Application No: FG/89/22/HH
Site Address: 4 East Mead Ferring BN12 5EA
Description of works: Single storey rear extension.

OWPC48507

FRONT SOUTH ELEVATION
PROPOSED ELEVATIONS
Scale 1:100

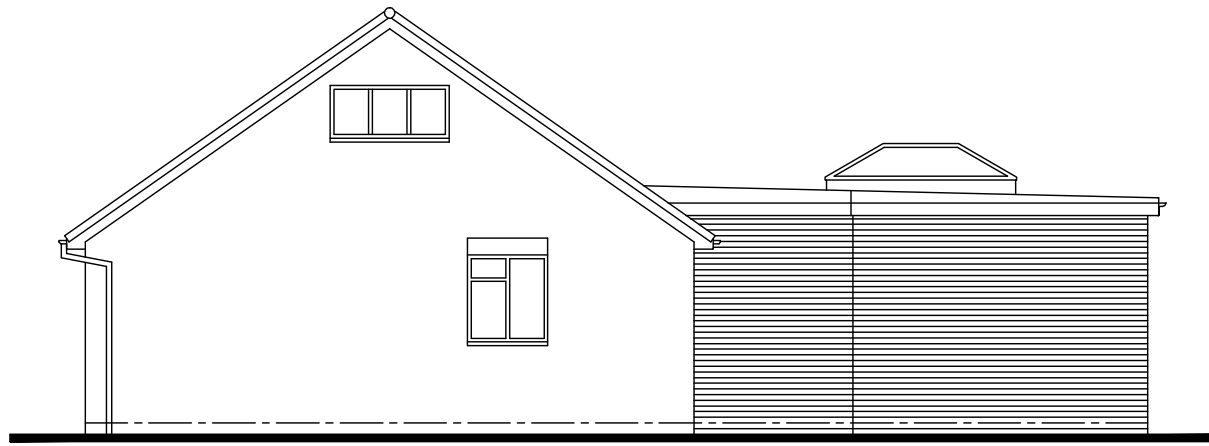
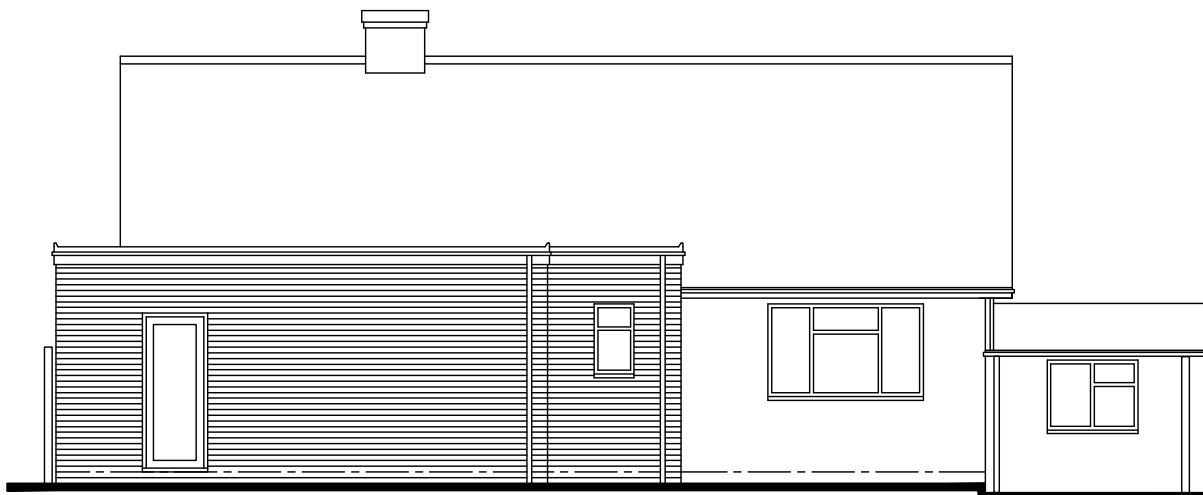
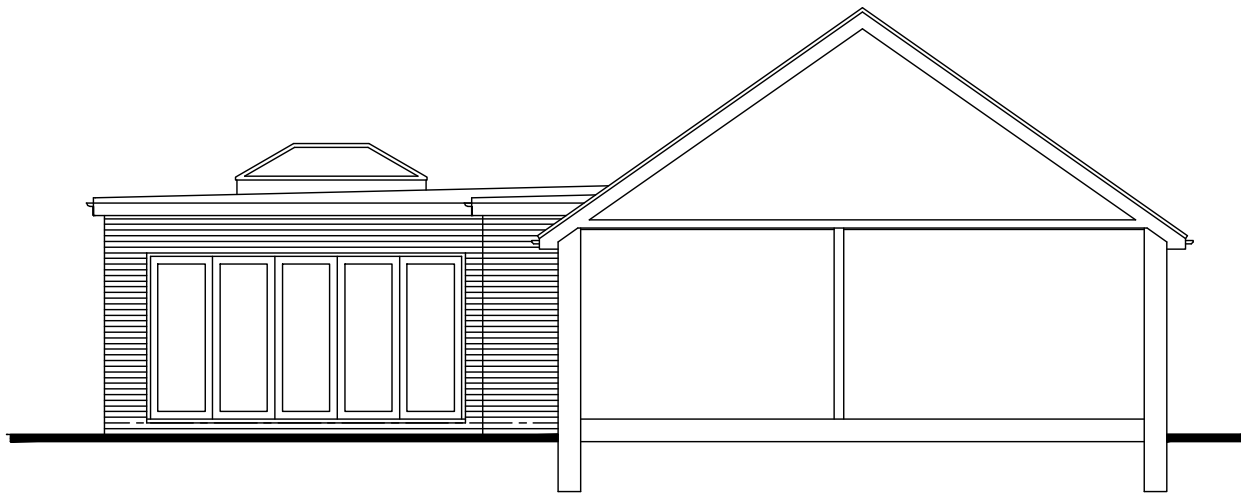
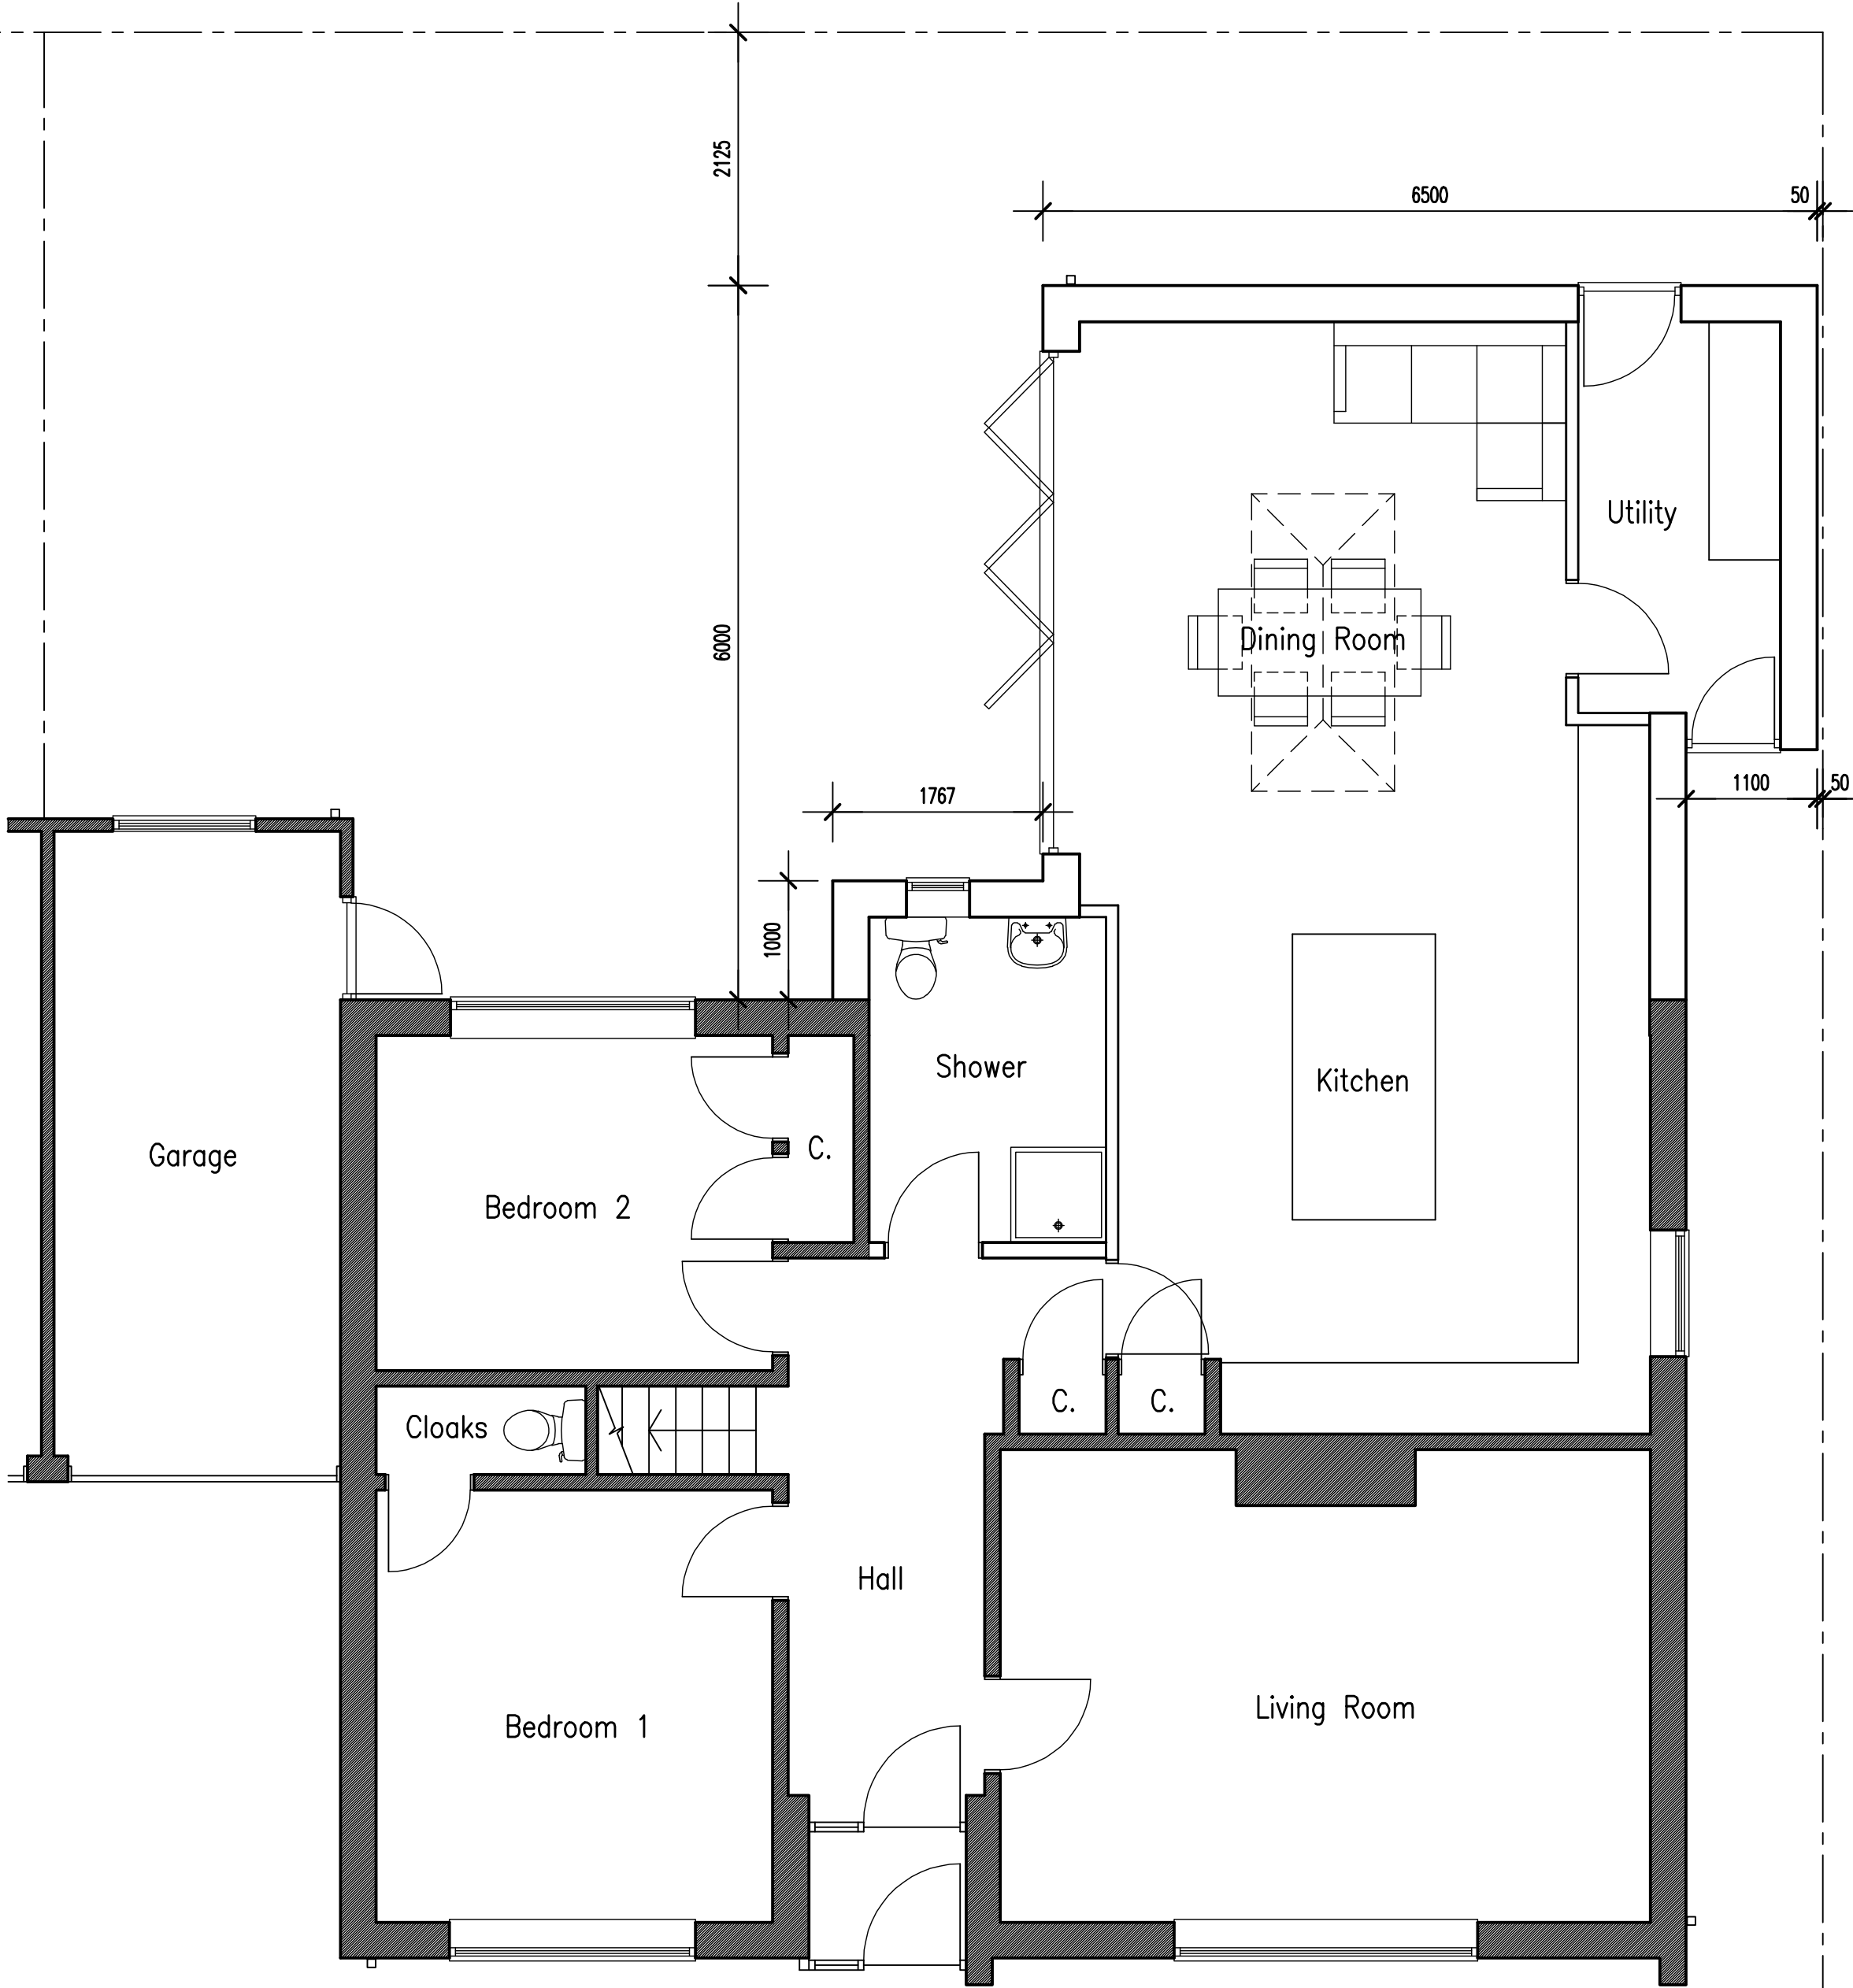
The proposed extension appears disproportionately large in relation to the host dwelling and site. As the development abuts the boundary and is higher than the existing facia, it would impose an overly dominant impact on the neighbouring residents.
